Rezoning Transportation Analysis

Petition Number: 2021-112

General Location Identifier: 04723120

Date	Description
09-21-21	First Review (BKB)
11-29-2021	Second Review (PDM)
01-27-2022	Third Review (PDM)

RZ-2: PARCEL IDENTIFICATION PLAN

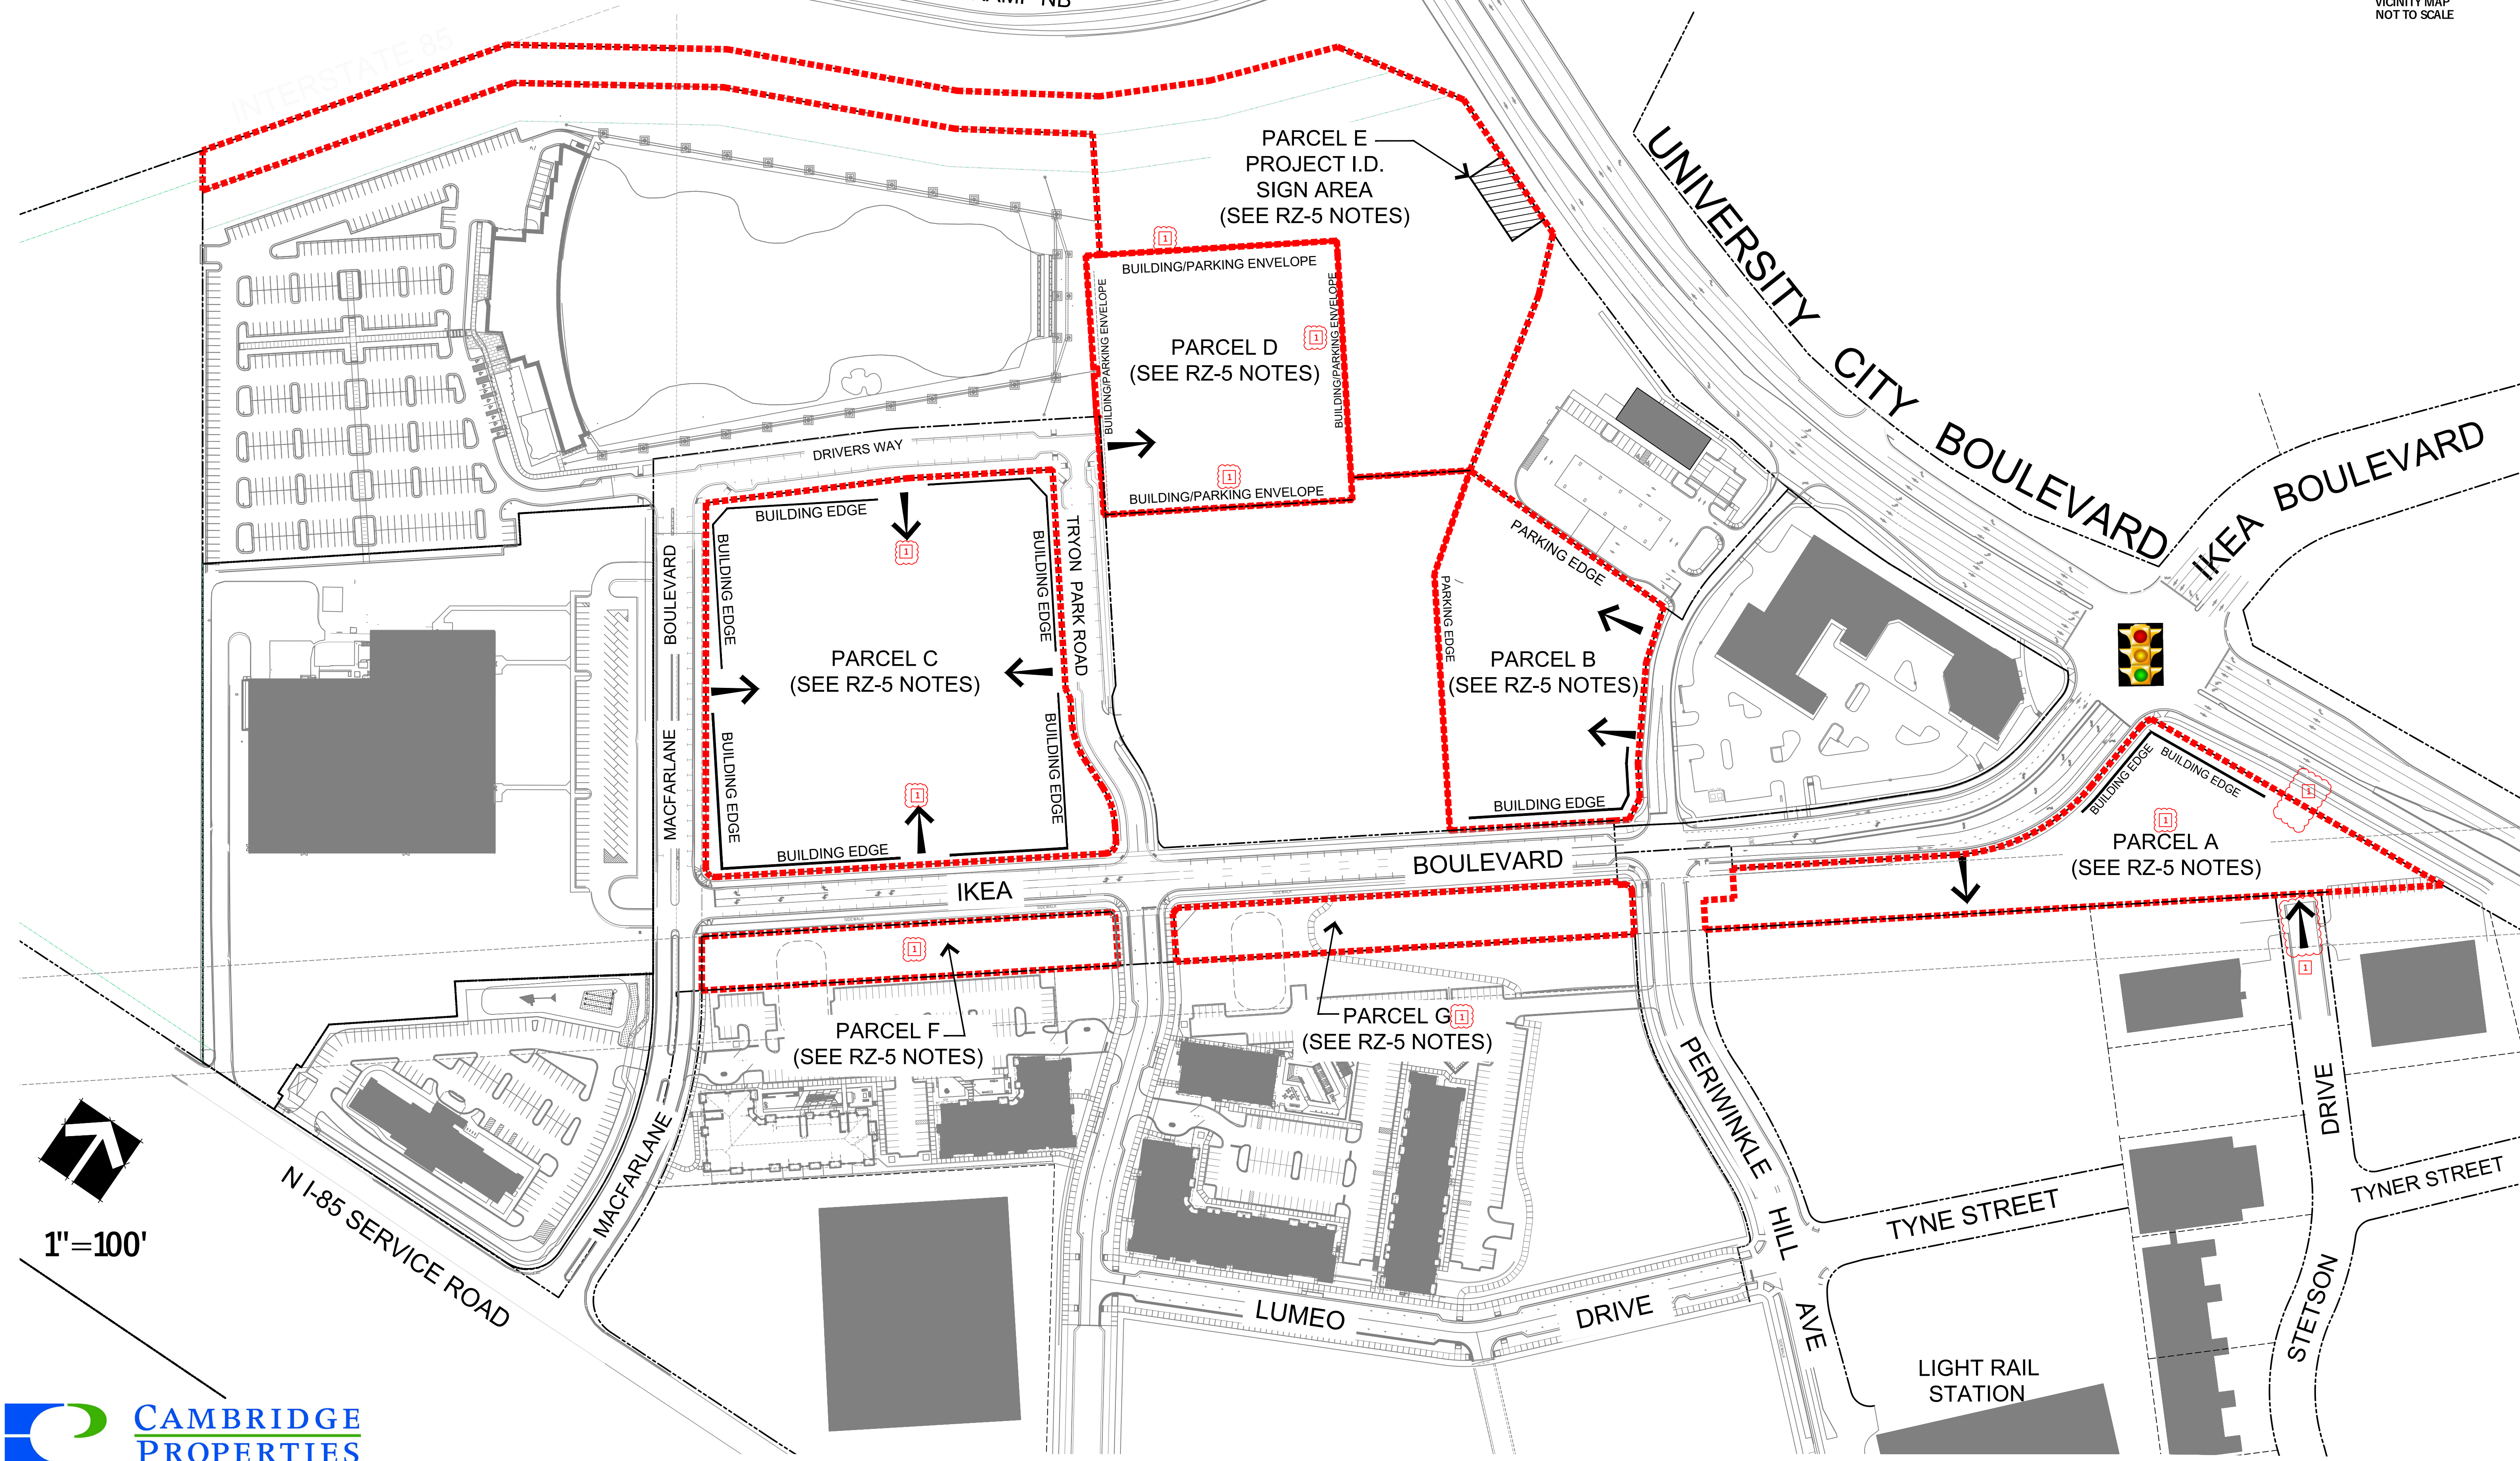
~~2. Access points are not permitted off of University City Boulevard. Revise site plan and general notes to reflect the access point to Parcel A being off Stetson Drive as opposed to the currently shown access point on University City Boulevard.~~
